**KEN BRIGHT ASSOCIATES PLLC**  
Consulting Engineers

May 17, 2023

**Ref: Lot 12 Fair Ridge Farms**

Purpose: On Friday, May 12, 2023, at the request of Tony Toro with Lamco Custom Builders, I went to Lot 12 on Fair Ridge Farms to make recommendations for the footing where water was found.

FOUNDATION PLAN
SCALE: 1" = 1/4"

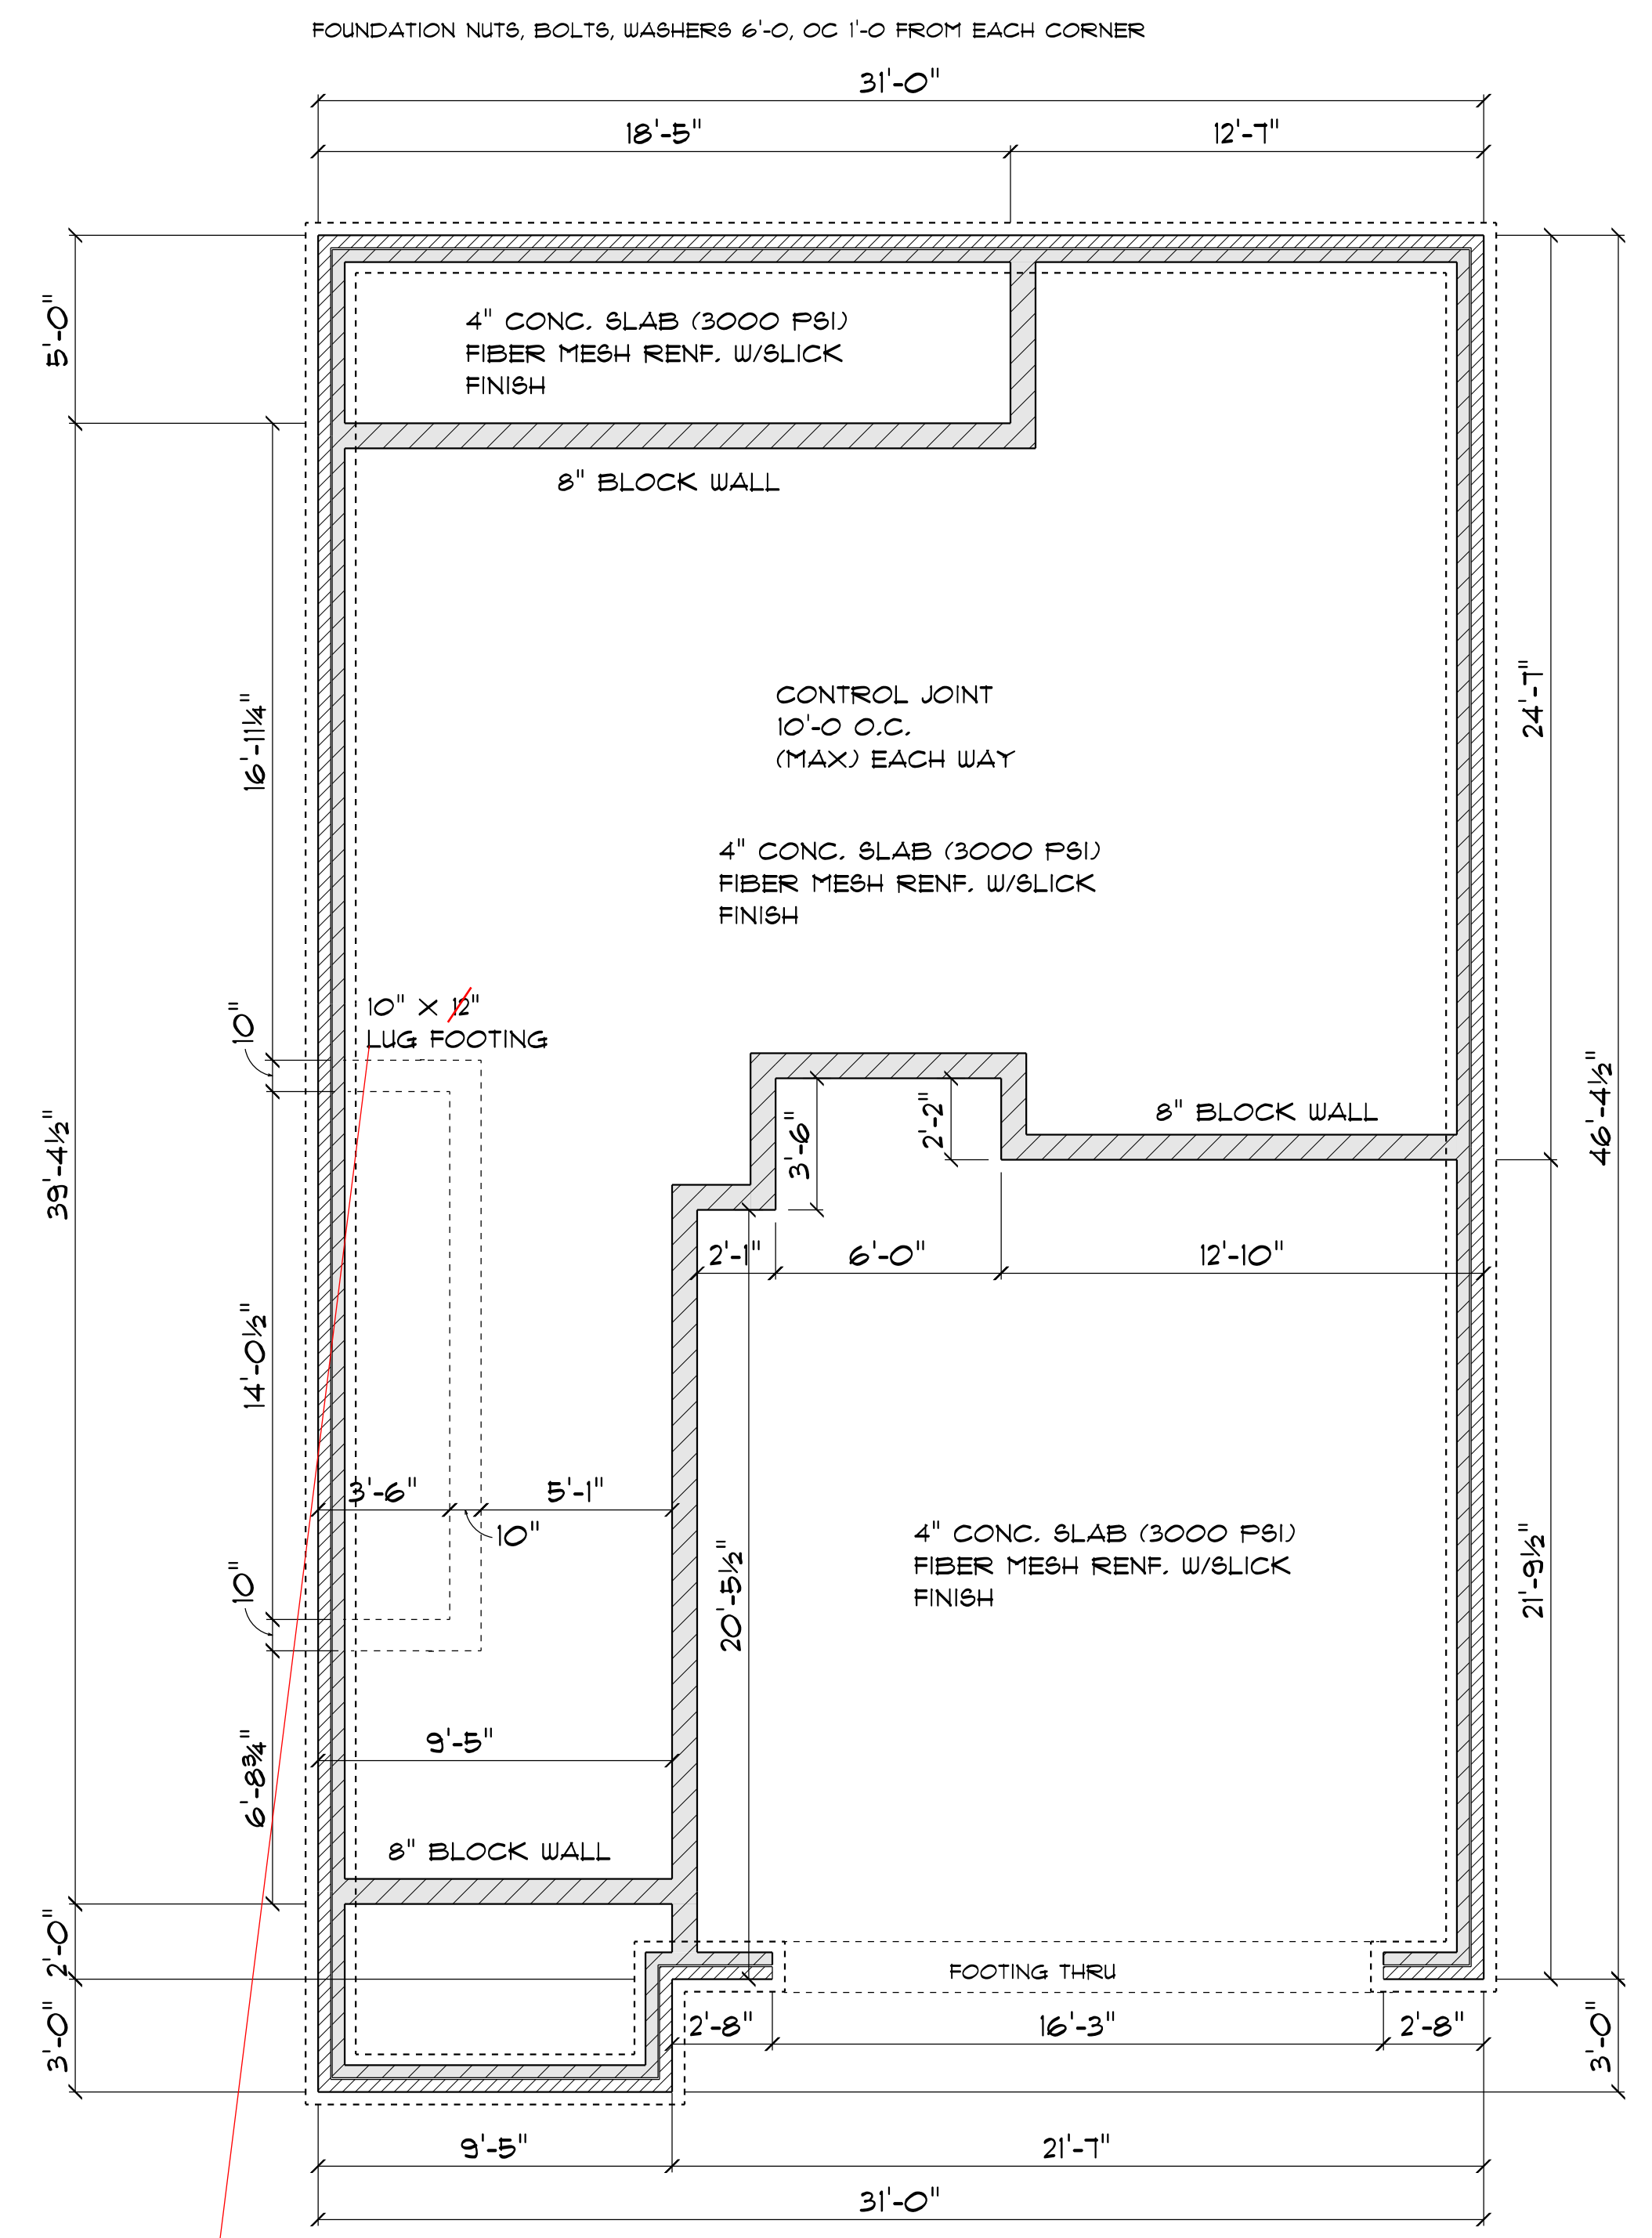
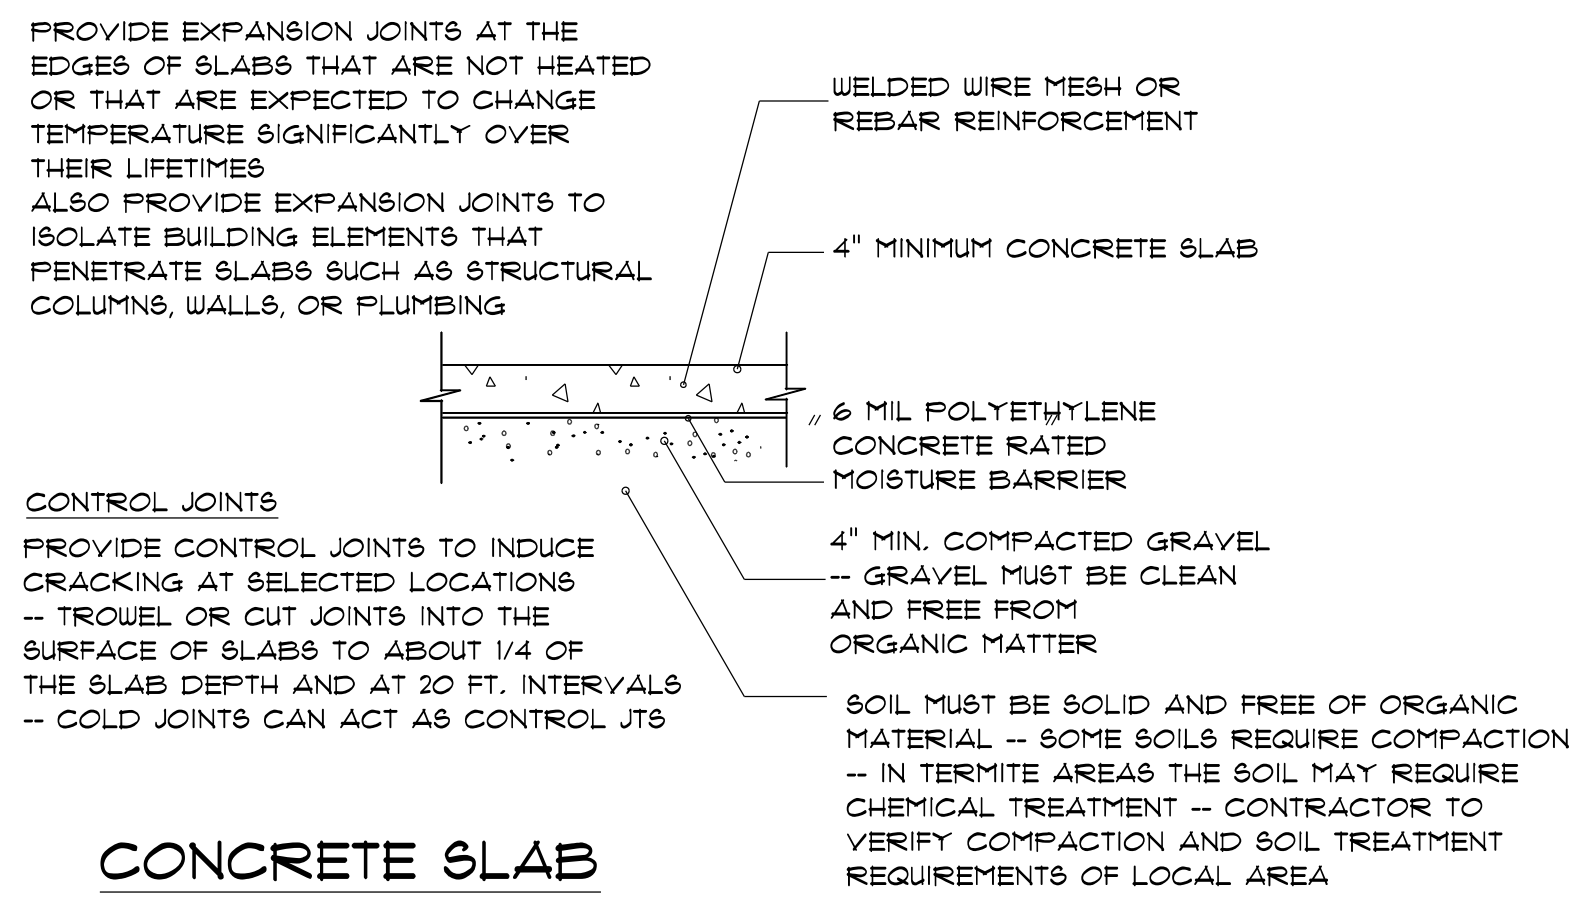
Observation: There was water in the trenches on the rear left side, rear right side, the rear and in a trench approximately 4 feet from the rear. Loose soil had been removed to solid ground at the time of the inspection. The dug trenches were 16" wide.

Recommendation: We recommend pumping out the water as much as possible and then placing a non-woven filter fabric to wrap the trench and add 8 inches of #57 or #67 stone. Flirter fabric to overlap 8" minimum after the stone is placed. Also, we instructed Mr. Toro to install 2#4 rebar 3" to 4" from the bottom in all trenches and to pour an 8" thick footing min.

With these modifications the footings will comply with the NC Residential Building Code.
